ENGINEERS SURVEY REPORT TO

**ELMSDALE HOUSE, 31 THE GREEN, MONEY LANE
WEST DRAYTON UB7 7PN**

PREPARED BY PRADEEP GUPTA - MIStructE, CEng.

DATED – 15TH June 2021

**PROPOSED
REAR ELEVATION**
Repairs & Alterations to
Boundary Wall and New
Lighting

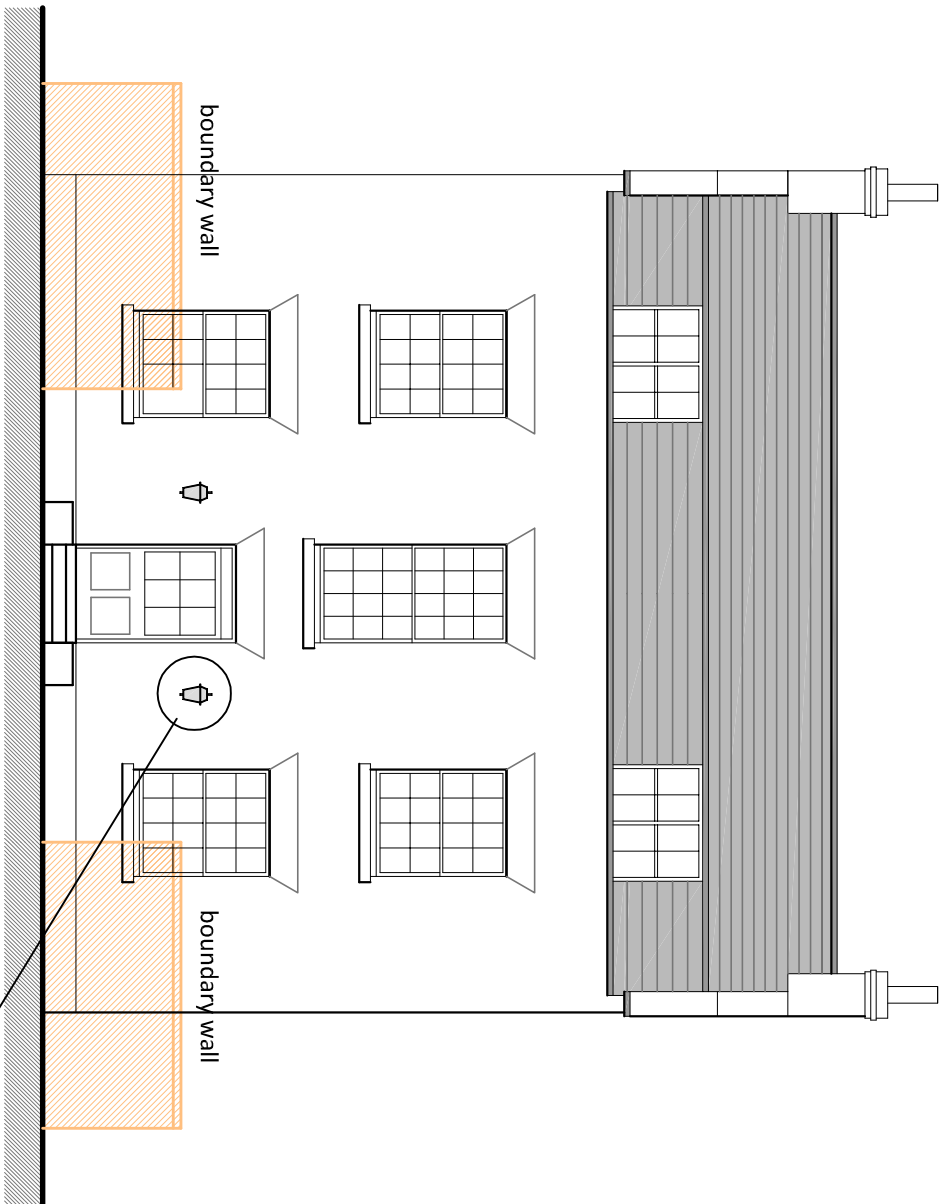
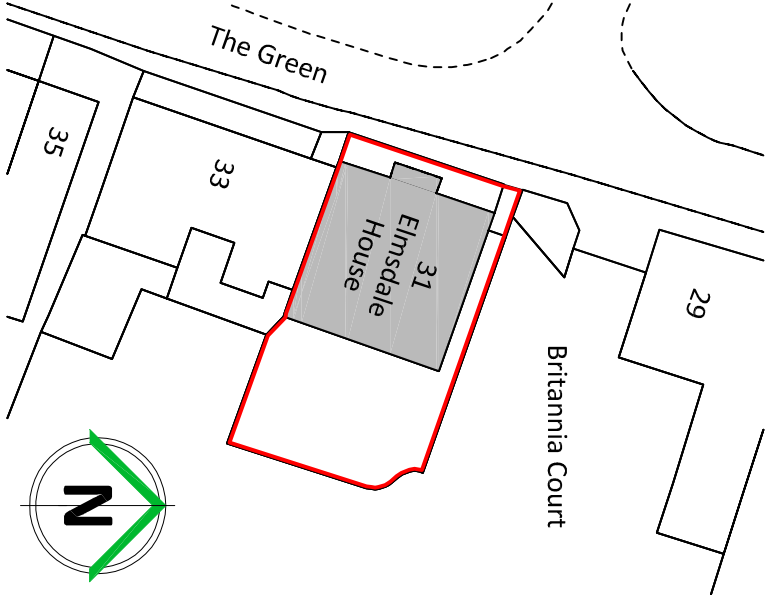
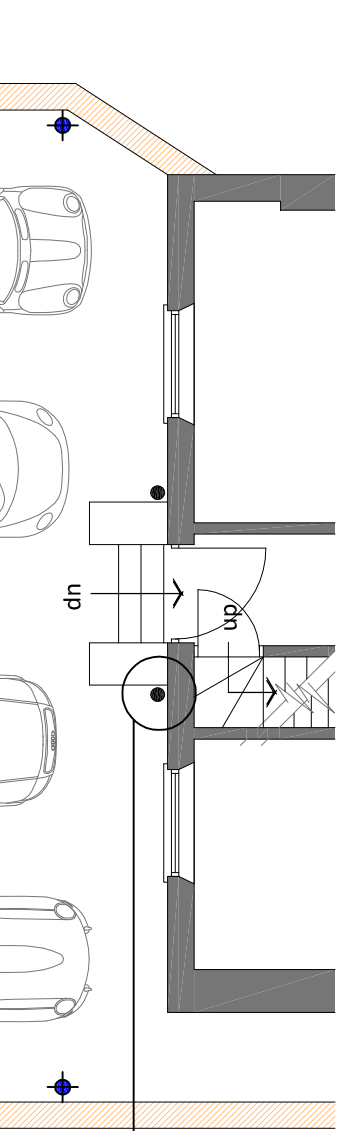
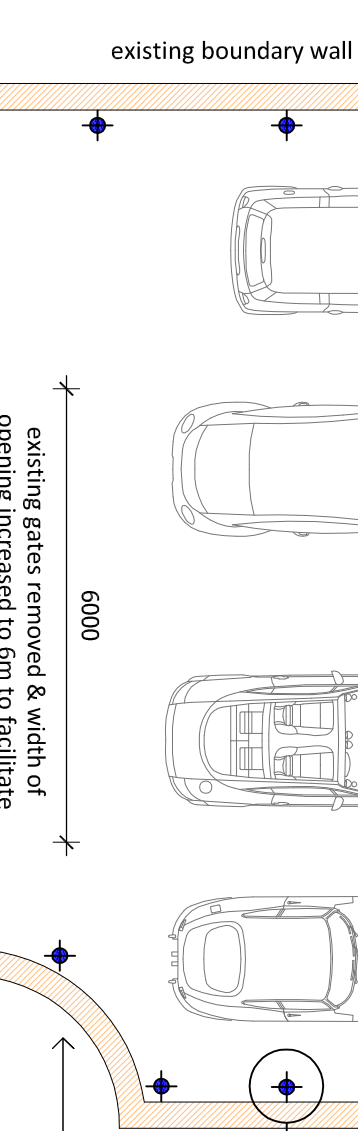
- 3.5 To the rear corner of left side boundary wall where it meets the curved boundary wall. The curved boundary wall is leaning outwards by 25mm at the top of the wall. There is also diagonal subsidence mode cracking to the bottom of the left side wall. This is due to the large shrubs in the adjoining planter with inadequate foundations to the wall. Trial pits will need to be dug to establish the foundation profile to the walls. The large shrubs will need to be removed and remained shrubs will need to be managed to ensure that they remain small. The walls will need to be underpinned locally, tied back to prevent any further lean and cracks will need to be stitched across using helibars.

EXTERNAL
STRUCTURAL
REPAIRS

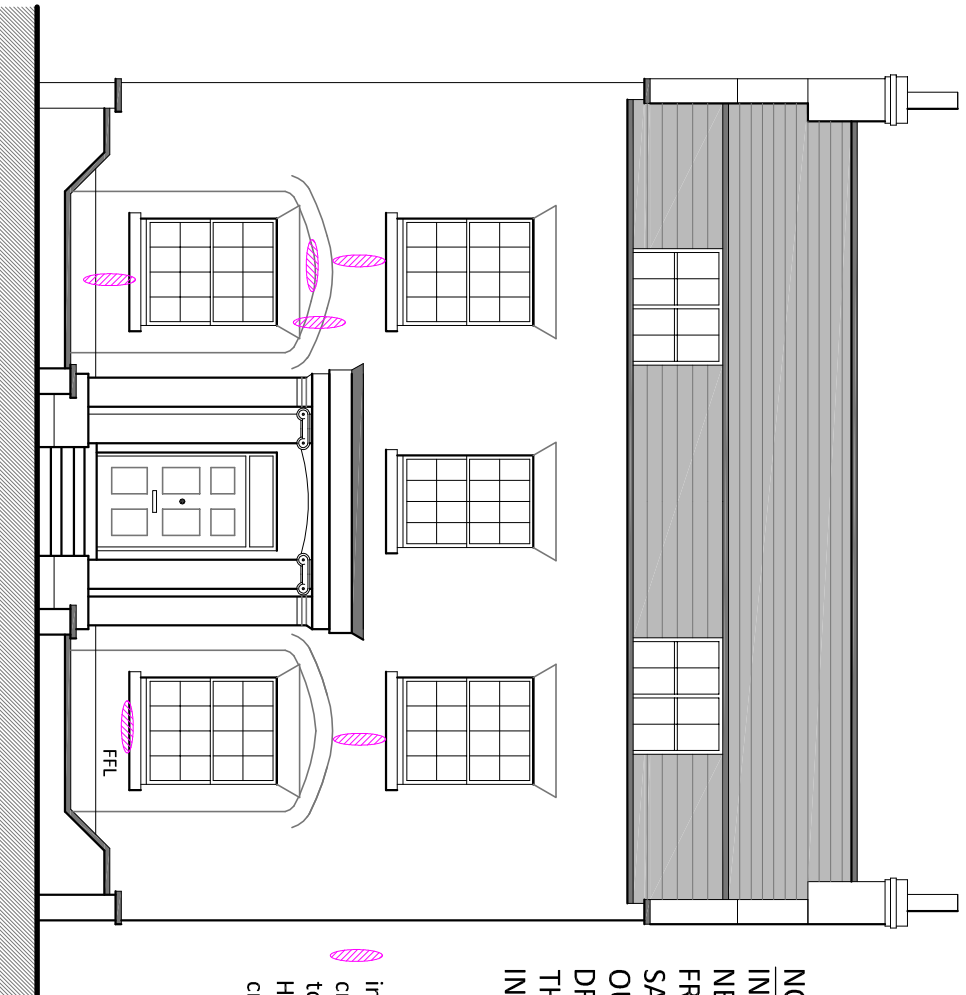
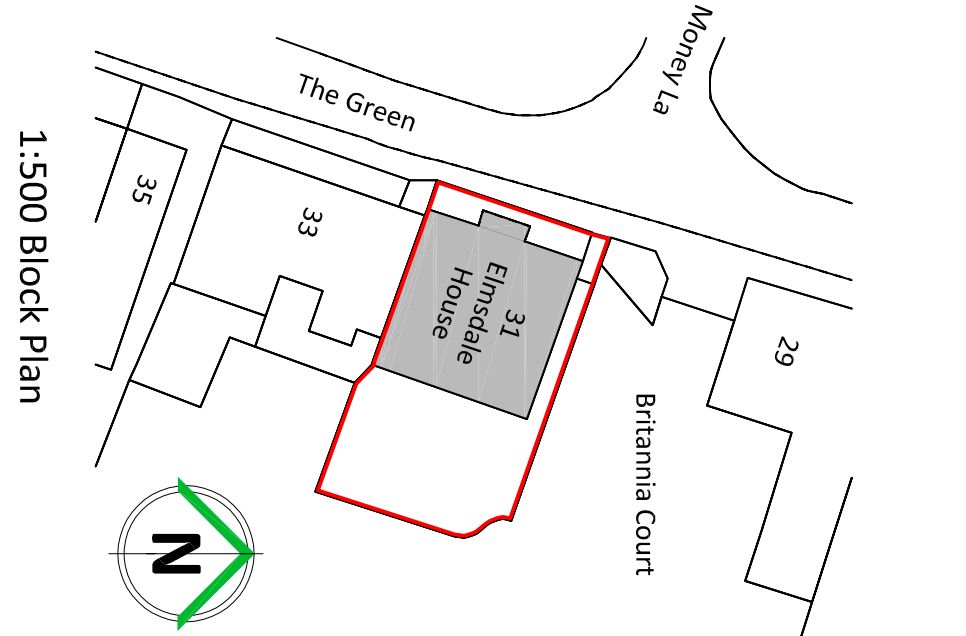
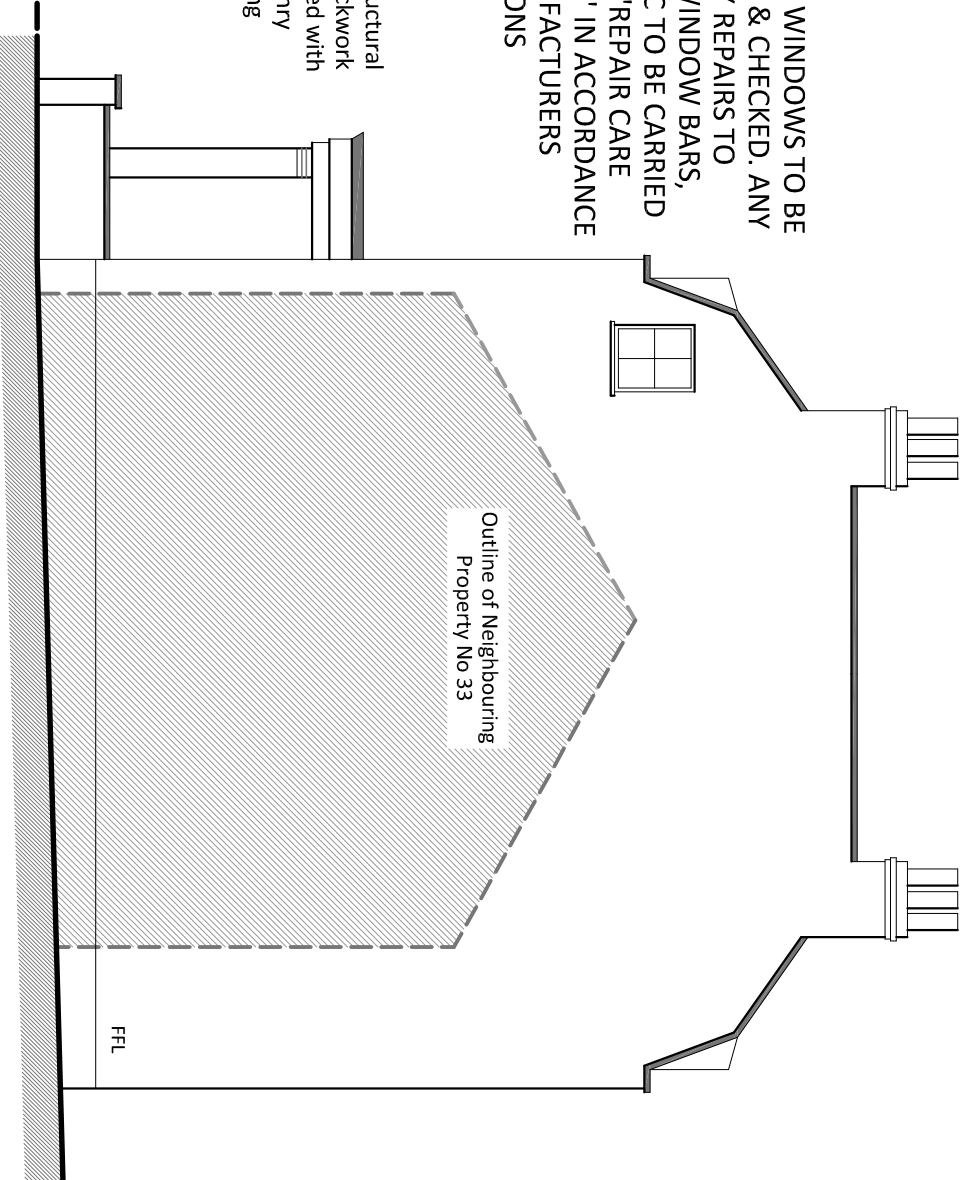
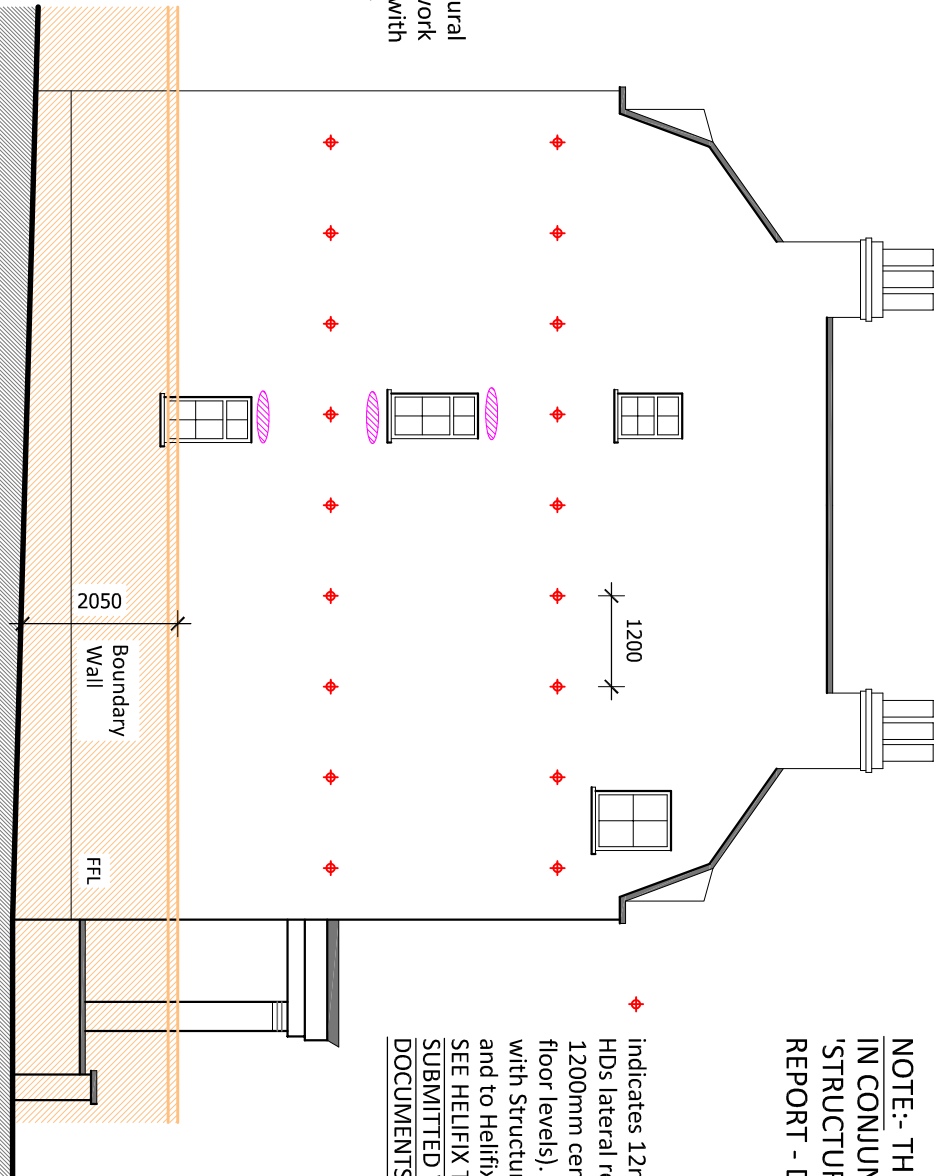
- 3.3 Inspection of the rear elevation indicated substantial movement to the ground floor right side window. There are vertical cracks from the ground level and damp-proof course level to the window. These cracks are due to the differential settlement of the wall to the cellar and the non-cellar. The flat arches over some of the other windows have also sagged due to the inadequacy of the timber lintels over the window openings. I would recommend any cracks visible externally should be stitched across using helibars.

- 3.4 To the left side elevation there was approximately vertical cracking between the ground, first and second floor windows. This is due to the wall bowing significantly. The reason for this is the lack of horizontal restraint from the floors to the wall as the floor joists are spanning parallel to the wall. I would recommend that the wall is tied back to the floors and the external cracking is stitched across using helibars.

Front Elevation (West Facing)

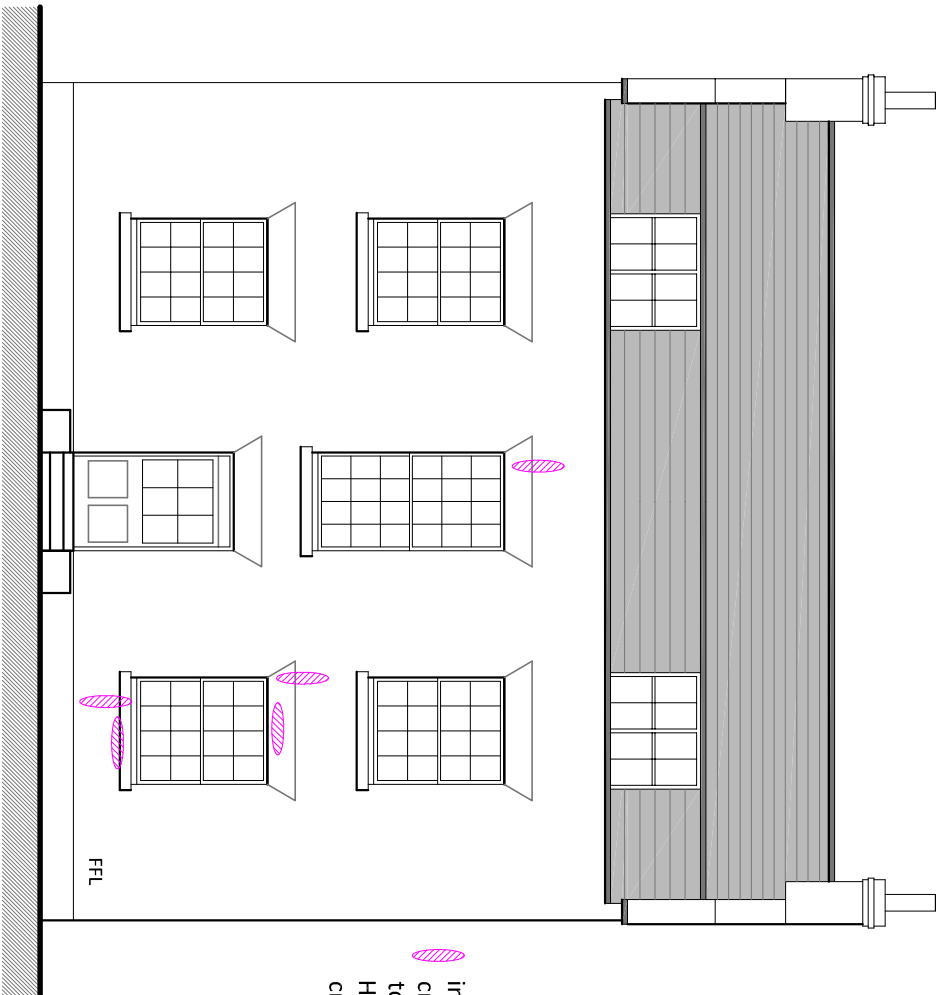
- 3.1 Inspection of the front elevation of the building indicated substantial movement to the left side of the building. This movement is present between the top of the ground floor left side window and the first-floor window directly above. This cracking is present in the flat soldier arch over the window, the relieving brick arch over the window and the brickwork between the windows. The sagging pattern of movement indicates inadequacy of the possible timber lintel over the window. The movement, although historic may be ongoing. I would therefore recommend the lintel over the window opening should be replaced with an adequately sized lintel. This will minimise any further movement. This work will need to be carried out very carefully without further disturbing the relieving arch. The external cracks, except for the flat arch and relieving arch can then be stitched across using helibars. The cracks to the flat arch and relieving arch can repointed as best as possible

- 3.2 The inspection of the remaining front elevation indicated hairline vertical crackling above the ground floor right side window and the first-floor middle window. There is also cracking to the brickwork under the ground floor left side window These cracks should be stitched across using helibars.
